Mark Dorsey
First Lamp Architecture
4915 S Rainier Ave S Ste 202
Seattle, WA 98118

Subject: Response letter for 2304-194 / DSR23-003 plan comments dated May 10th, 2023.

Summary of drawing changes

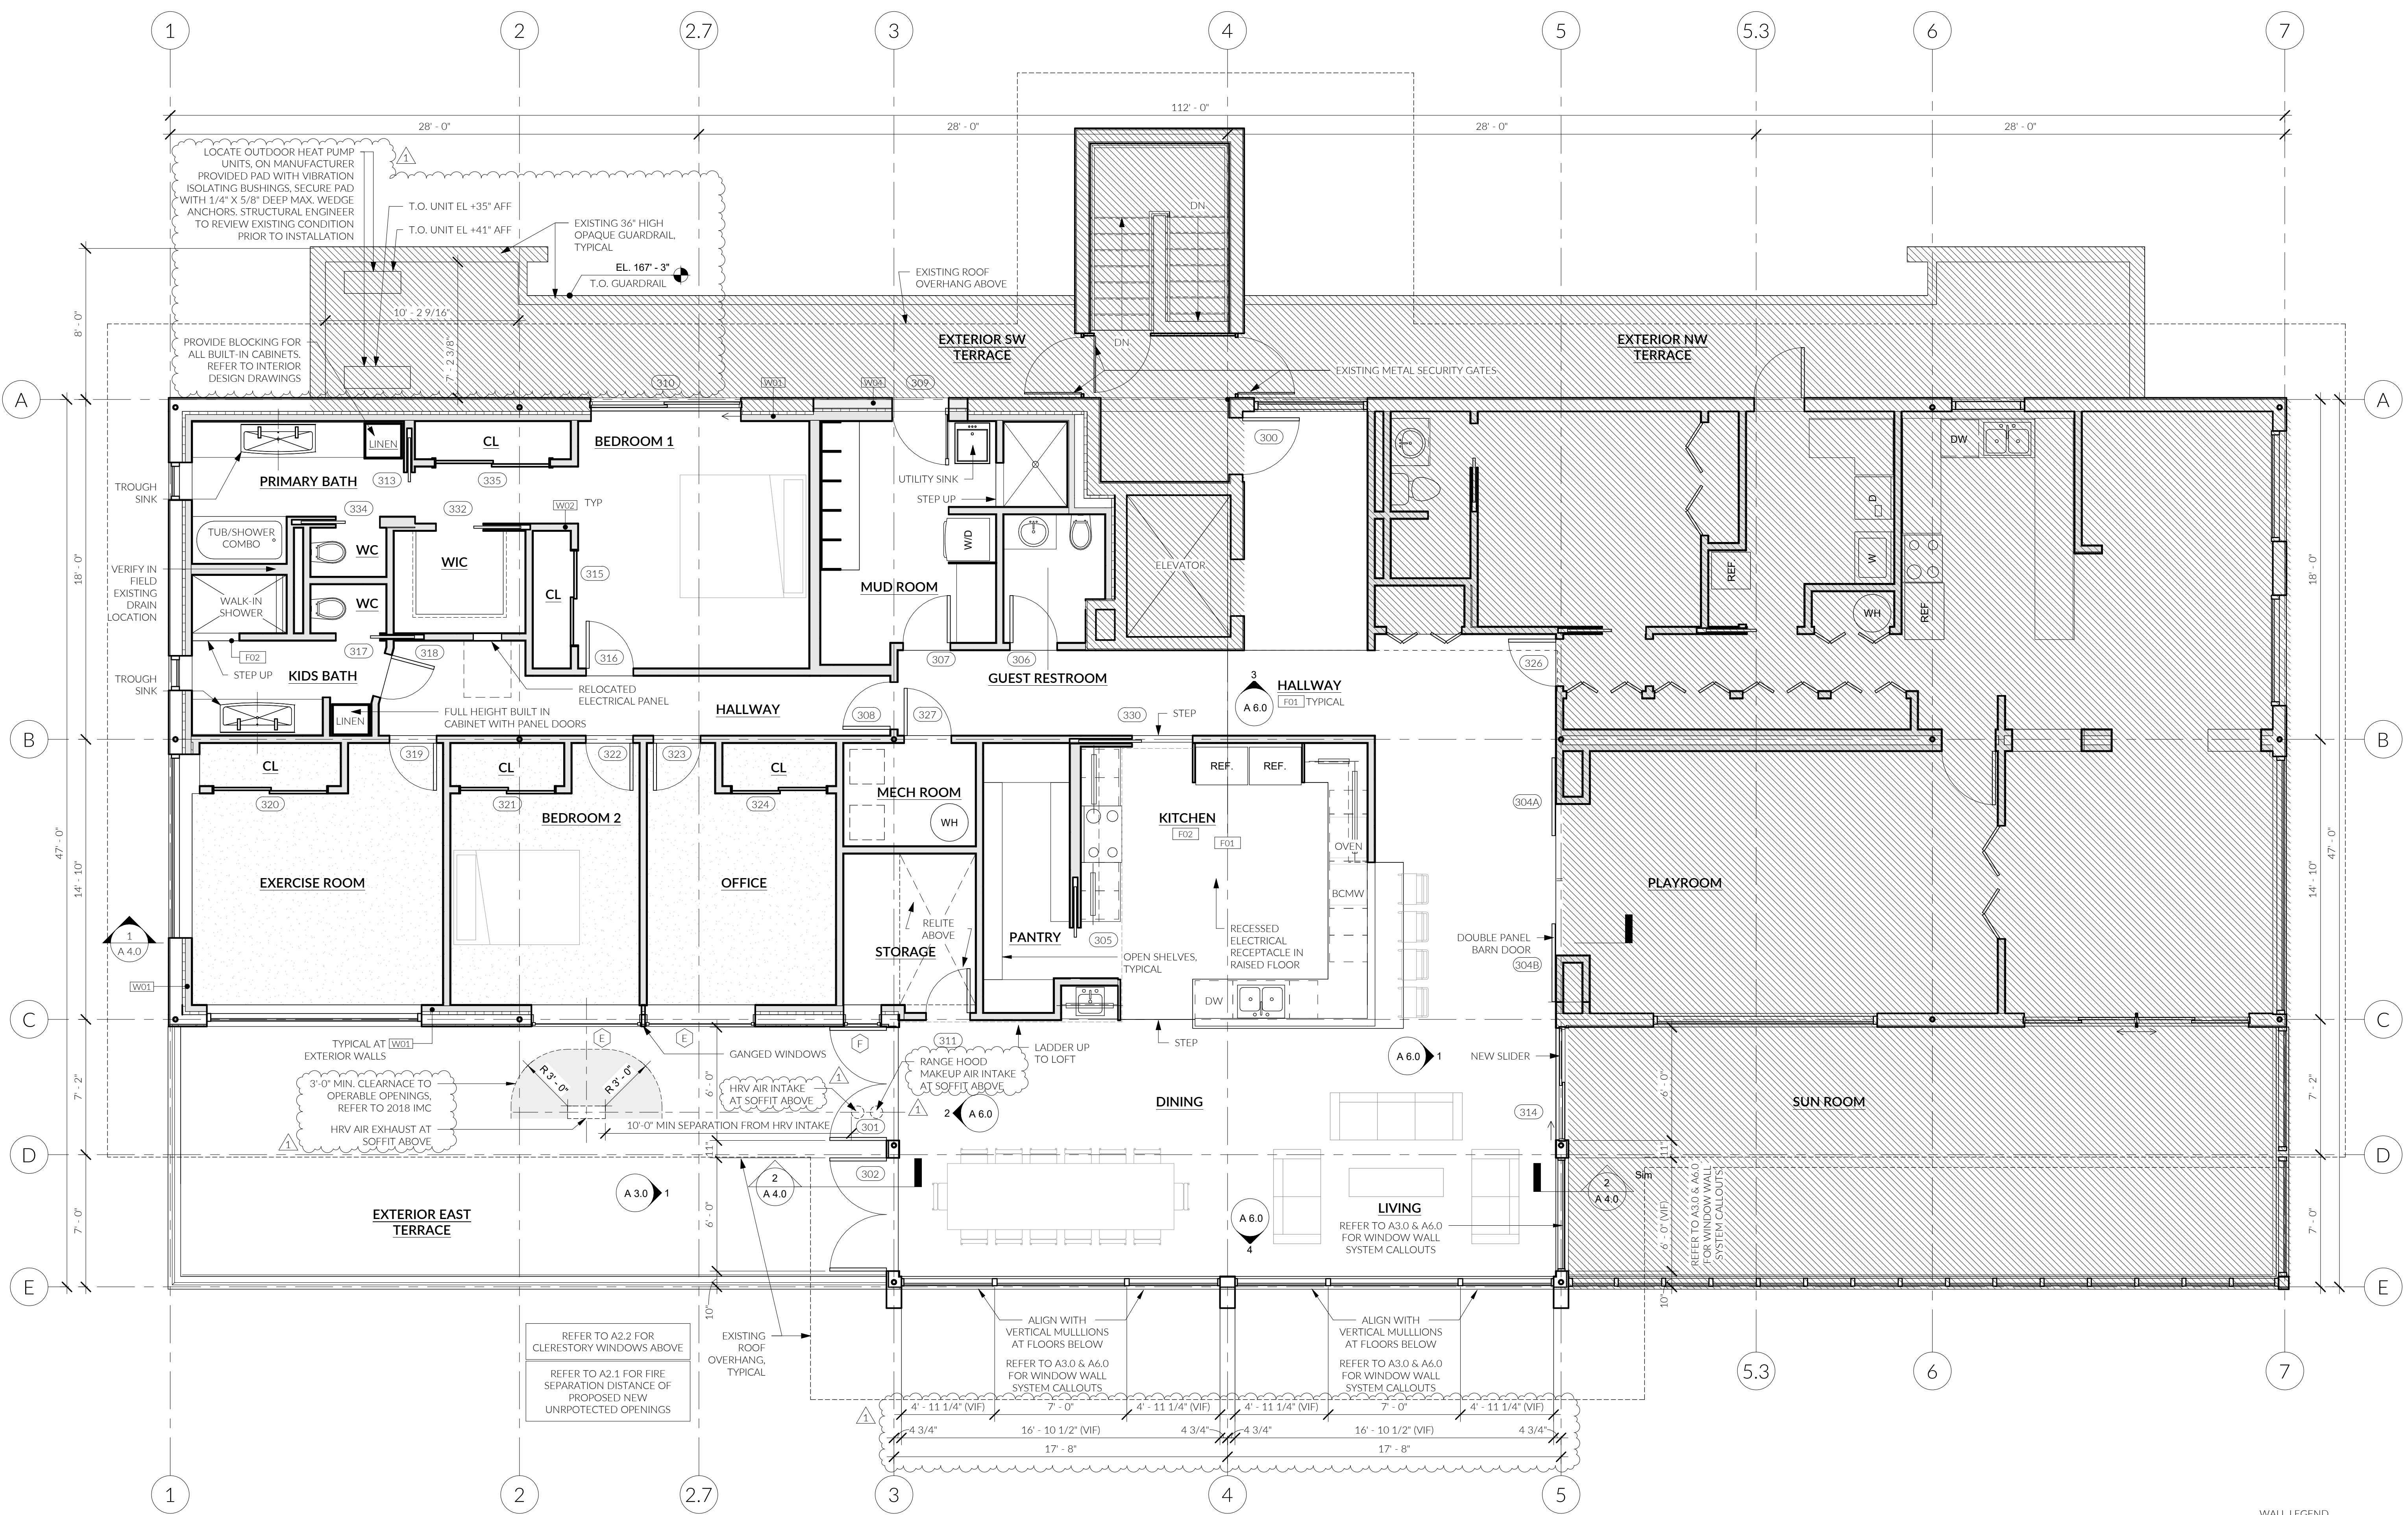
A2.1 - PENTHOUSE FLOOR PLAN

Added location of heat pump outdoor units, HRV intake and exhaust, and range hood makeup air intake locations. Adjusted vertical mullion spacing at East facing windows between gridlines 3 & 5.

EXTERIOR ELEVATIONS

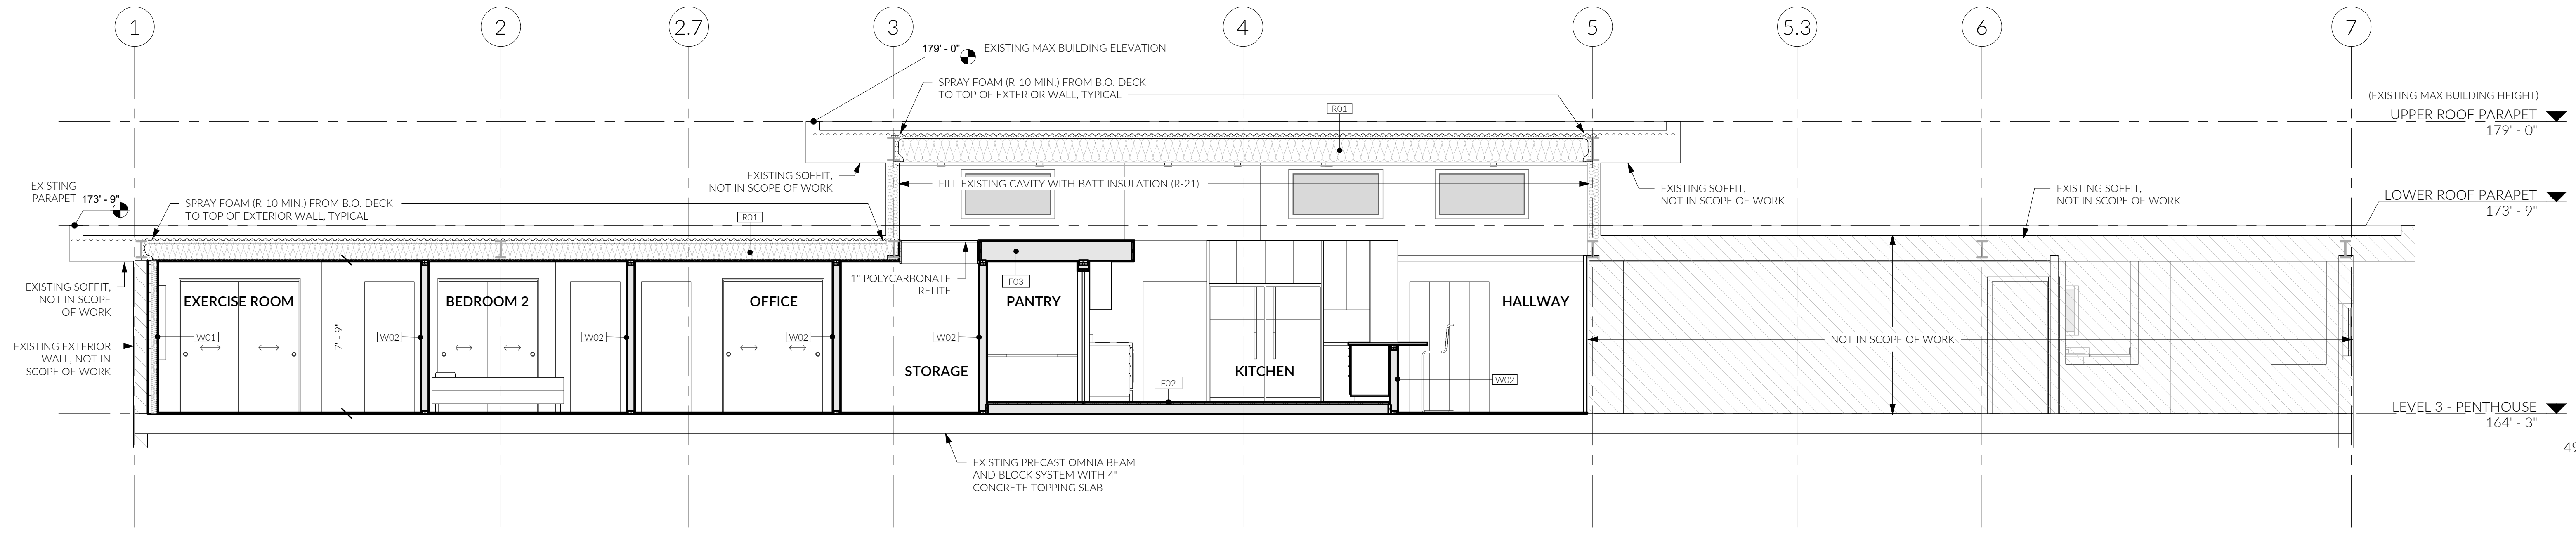
A3.0 - EXTERIOR ELEVATIONS

**Photo Sketch B/A3.0 - Removed HRV exhaust from roof, added note at replacement windows.
1/A3.0 - Added note to clarify new exterior finishes to match existing finishes.**
